From: Andrew Wood <Andrew.Wood@arun.gov.uk>
Sent: 23 February 2021 15:10
To: Planning.Responses <Planning.Responses@arun.gov.uk>
Subject: FW: Arundel Road, Walberton: Planning Consent WA/63/19/PI

Subject: RE: Arundel Road, Walberton: Planning Consent WA/63/19/PI

Andrew -- Based upon the current drawings/calculations/maintenance manual, I can now confirm that the proposals are acceptable. This relates to conditions 6 and 7. It would be a good idea to upload all the correspondence on this matter to the planning portal.

Drawing Title			
Engineering Details			
Standard Construction Details			
Drawn	Checked	Issue Size	Date
YKH	1:25	A1	08/20
10/18	1:25	1A	10/18
KNC1822		501-01	A

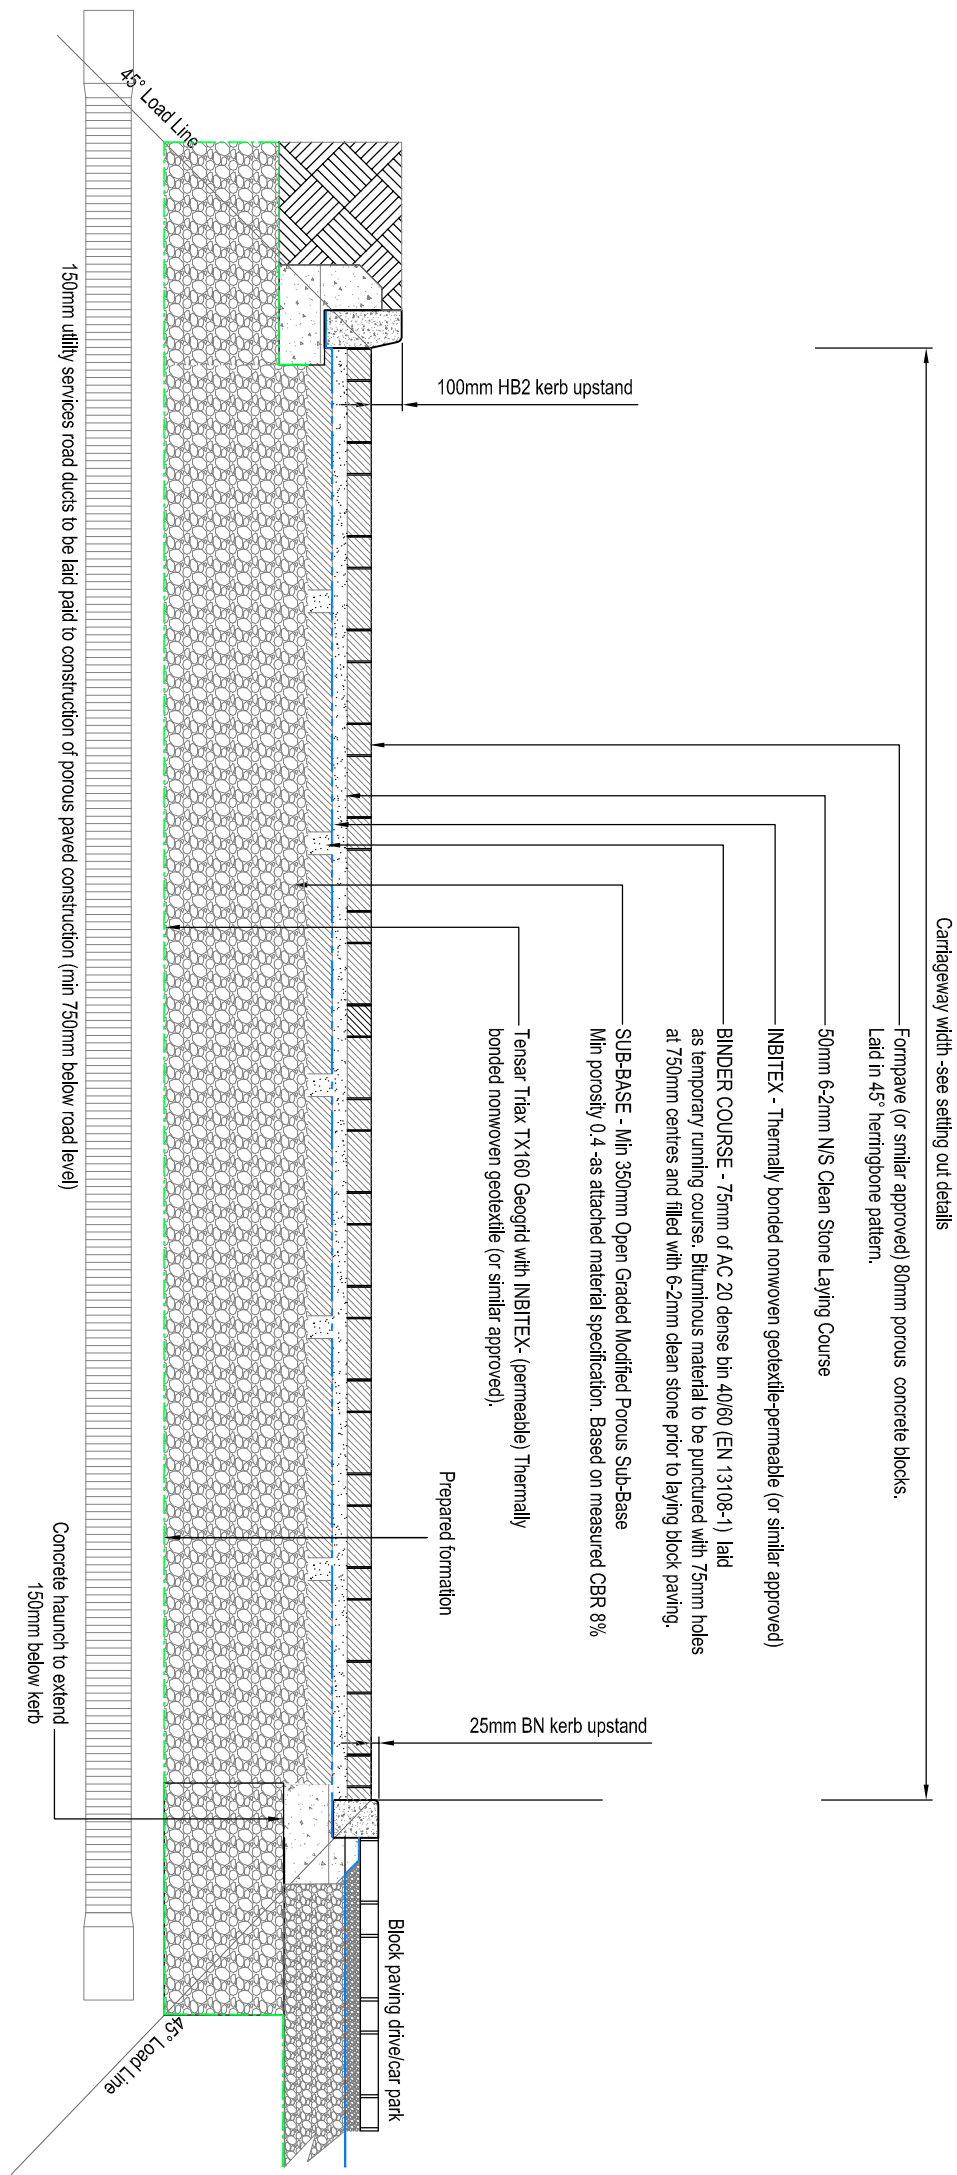
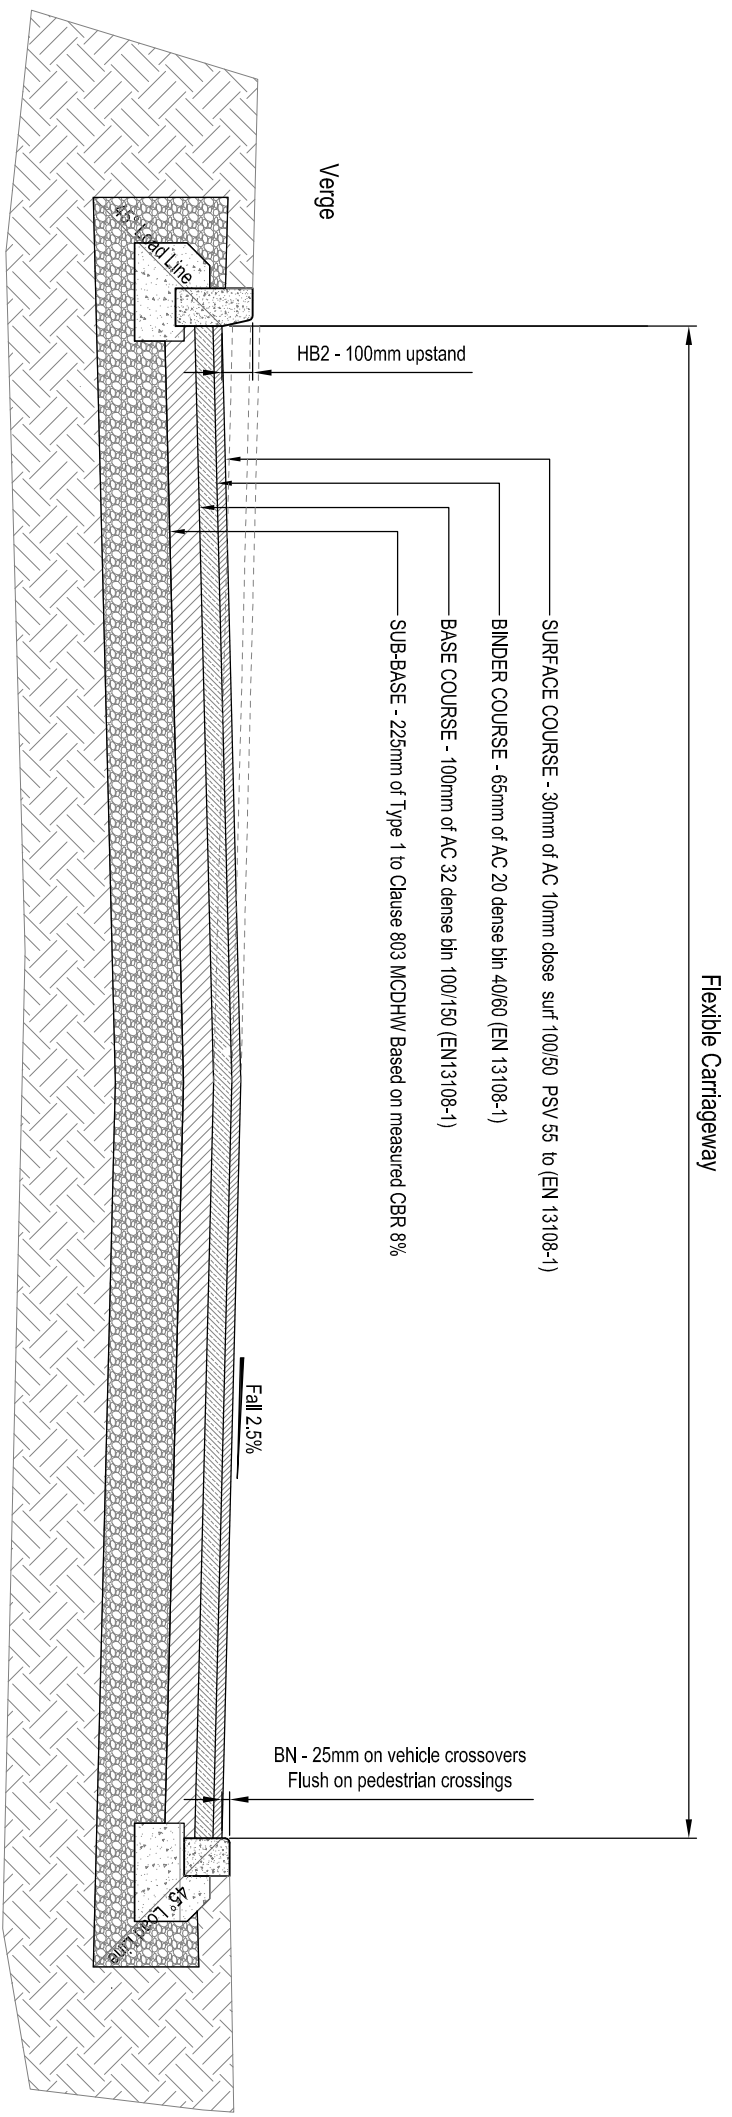
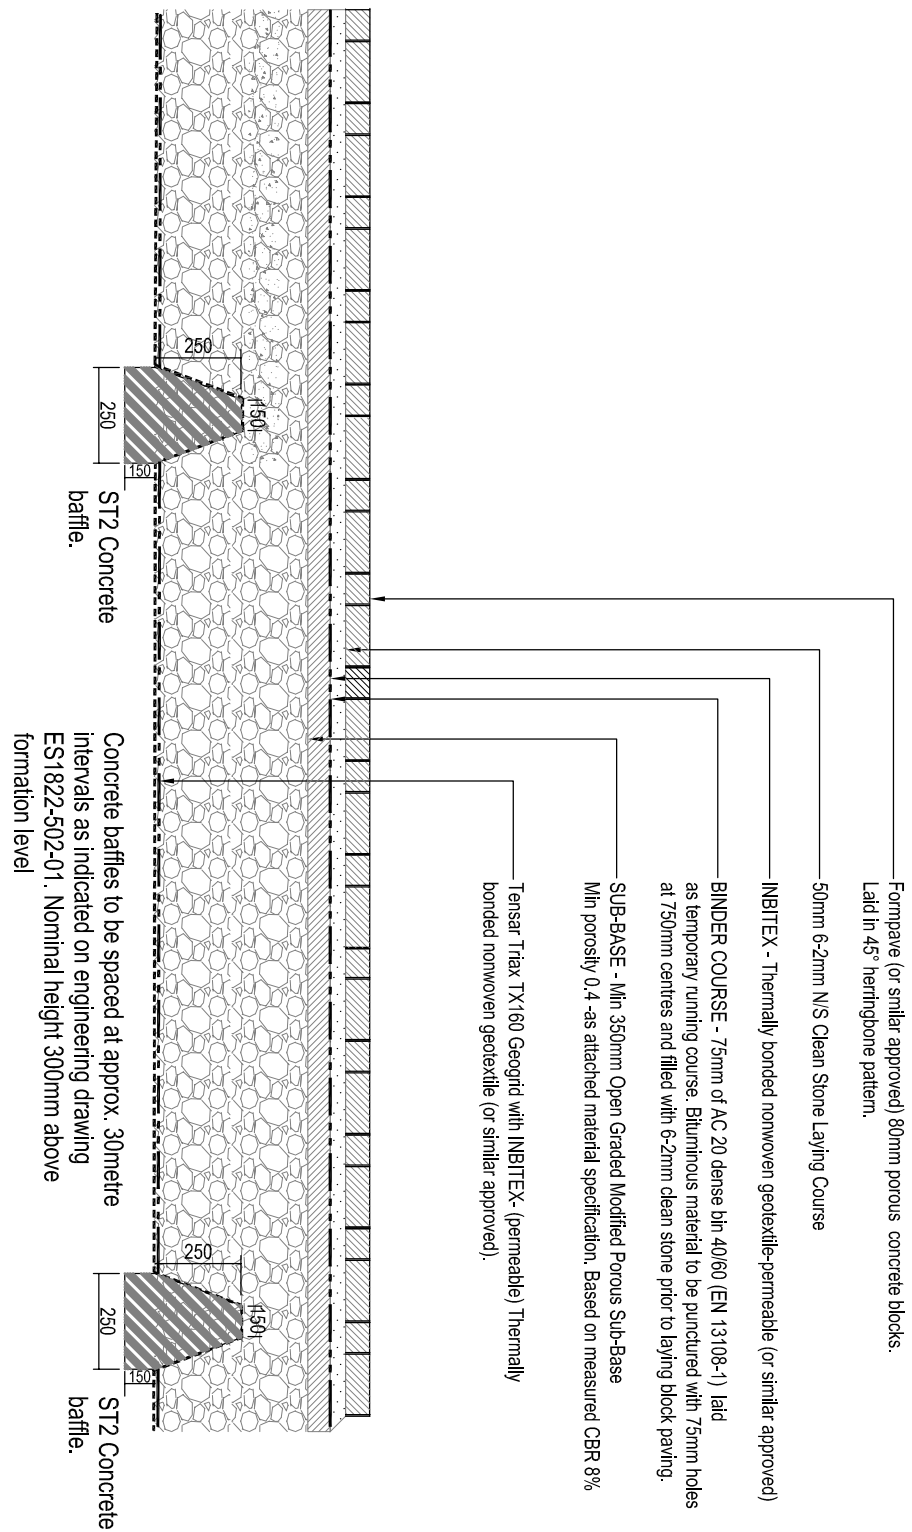
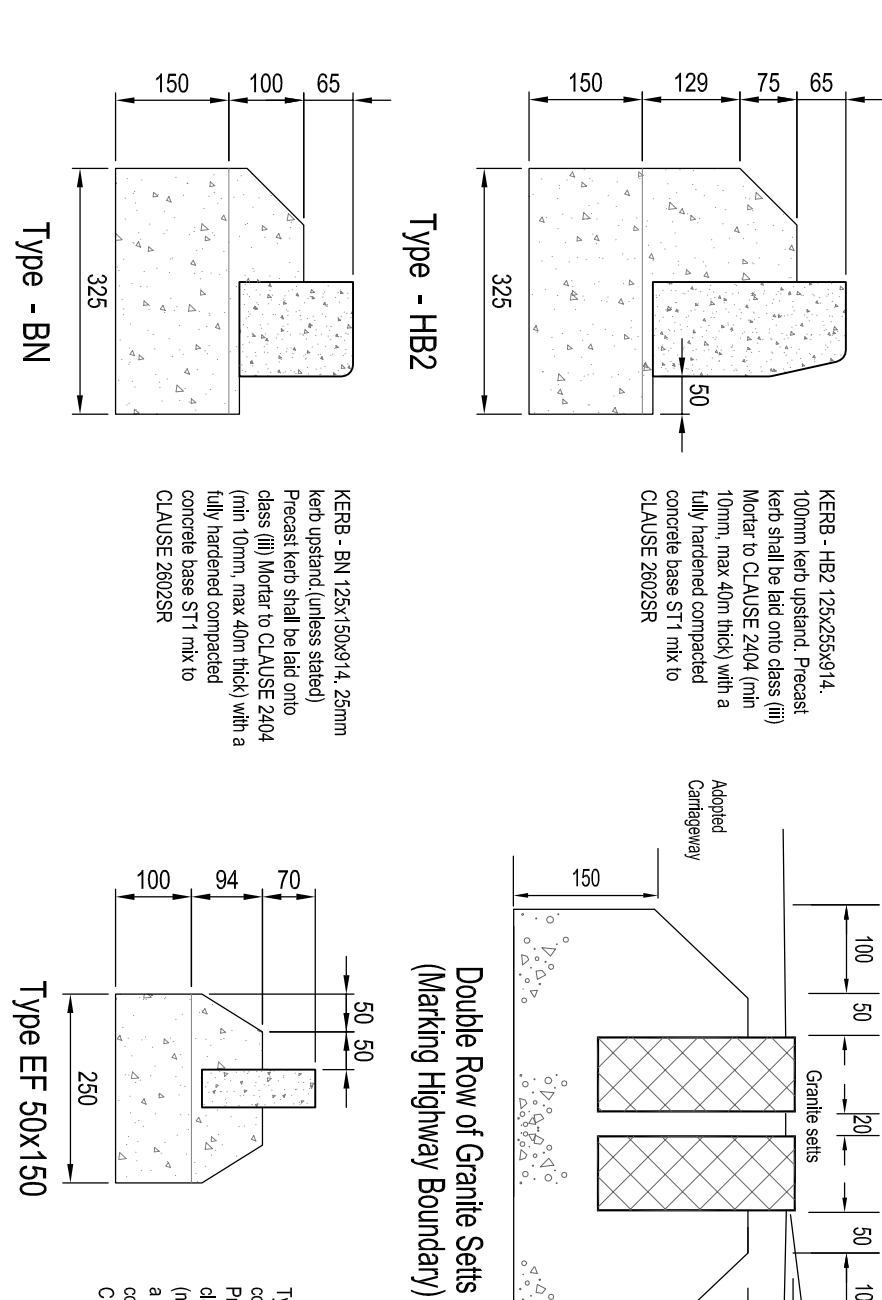
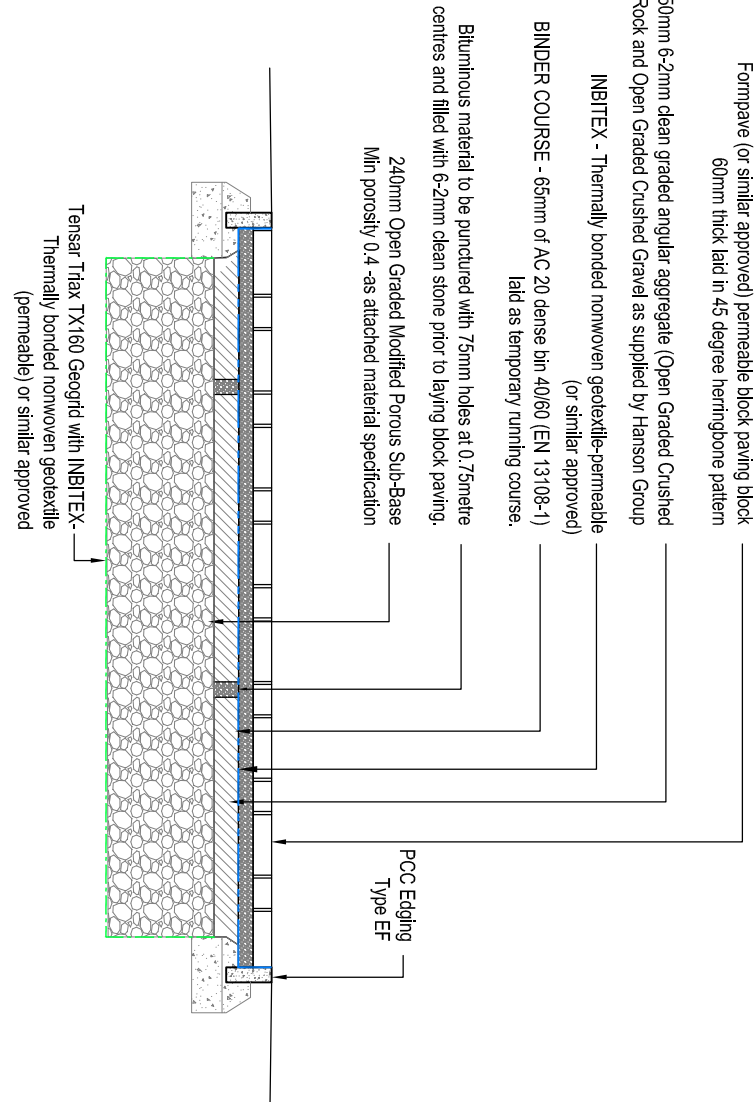
9. Specify sump depth on silt trap manhole detail. Sump depth added ok
10. Specify construction details for bellmouth channel drain. Channel detail added. ok

11. Permeable paving construction details – provide geotextile between binder course and sub base, also between concrete and sub base on access road construction. Additional geotextile incorporated ok

12. Soakaway construction detail;
 - a) Specify permeable geotextile and make it clear that the granular material is to be fully wrapped. Note added ok
 - b) Dimension positioning of pipework from perimeter of granular fill. Dimension shown ok

- c) Replace 4 way junction pipe with 3 way or specify end cap to unused connection. Detail amended to 3 way junction ok
13. Calculations;
 - a) Some cover/invert levels do not reflect those in soakaway schedule on the plan. Calculations and levels amended to accord. ok

There appears to be some discrepancies in the calcs, for example, taking the 1 in 100 year calcs. Top of storage taken as invert level of incoming pipe as per construction detail ; I have amended the standard detail to show the granular backfill up to the underside of topsoil and included on the soakaway schedule a level for the top of the granular fill. Top of storage for the 1 in 100yr calcs is the ground level less allowance for topsoil, shown as 'Cap Volume' on Page 4 of calculations. The calculations show there to be no overtopping of the designed soakaway, ie no garden flooding if the Cap volume had been exceeded.
